**CITY OF ALBUQUERQUE  
PLANNING DEPARTMENT  
February 19, 2014  
DRB Comments**

**PROJECT # 1009969**

**APPLICATION # 14-70037**

**RE: Lot 17-A, Pappe Addition**

# SKETCH PLAT OF LOT 17-A-1, 17-A-2, 17-A-3 PAPPE ADDITION PROJECTED SECTION 5, T. 10 N., R. 3 E., N.M.P.M. CITY OF ALBUQUERQUE BERNALILLO COUNTY, NEW MEXICO FEBRUARY, 2014

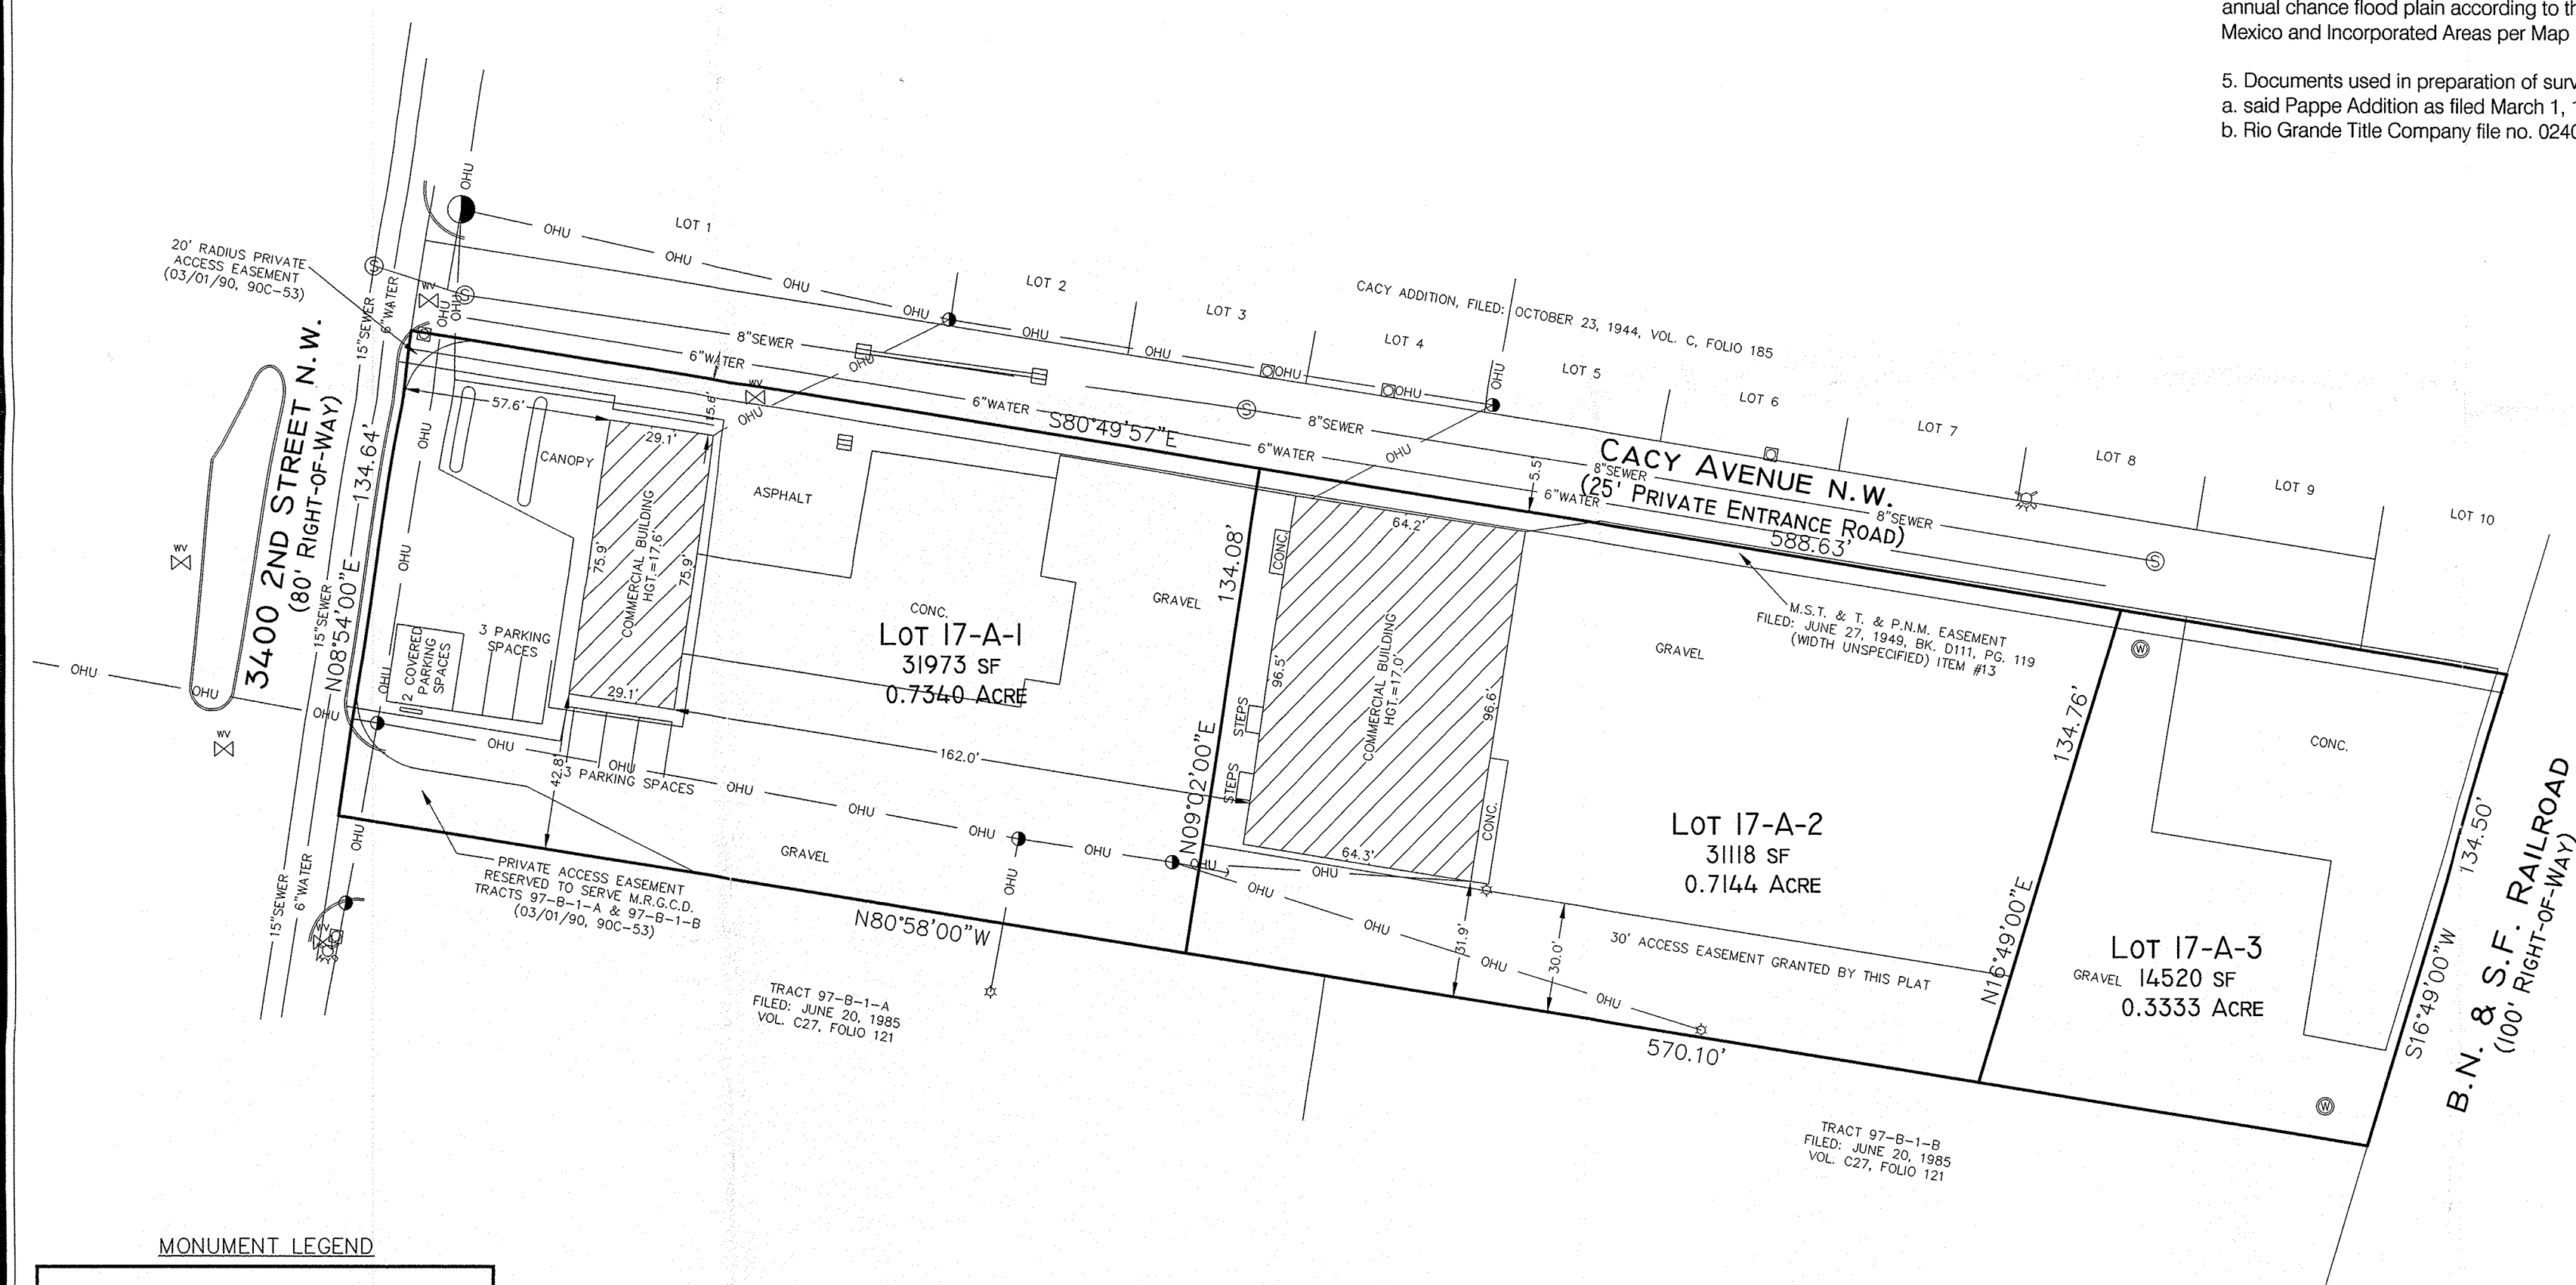
AGIS shows Cacy Ave NW as public right of way not a private road – more information is needed. In any case, additional width, pedestrian access, vehicular turnaround and associated improvements appear needed – refer to comments from Transportation Development.

Parking calculations and layout are needed to demonstrate on-site parking requirements can be met on proposed lot(s).
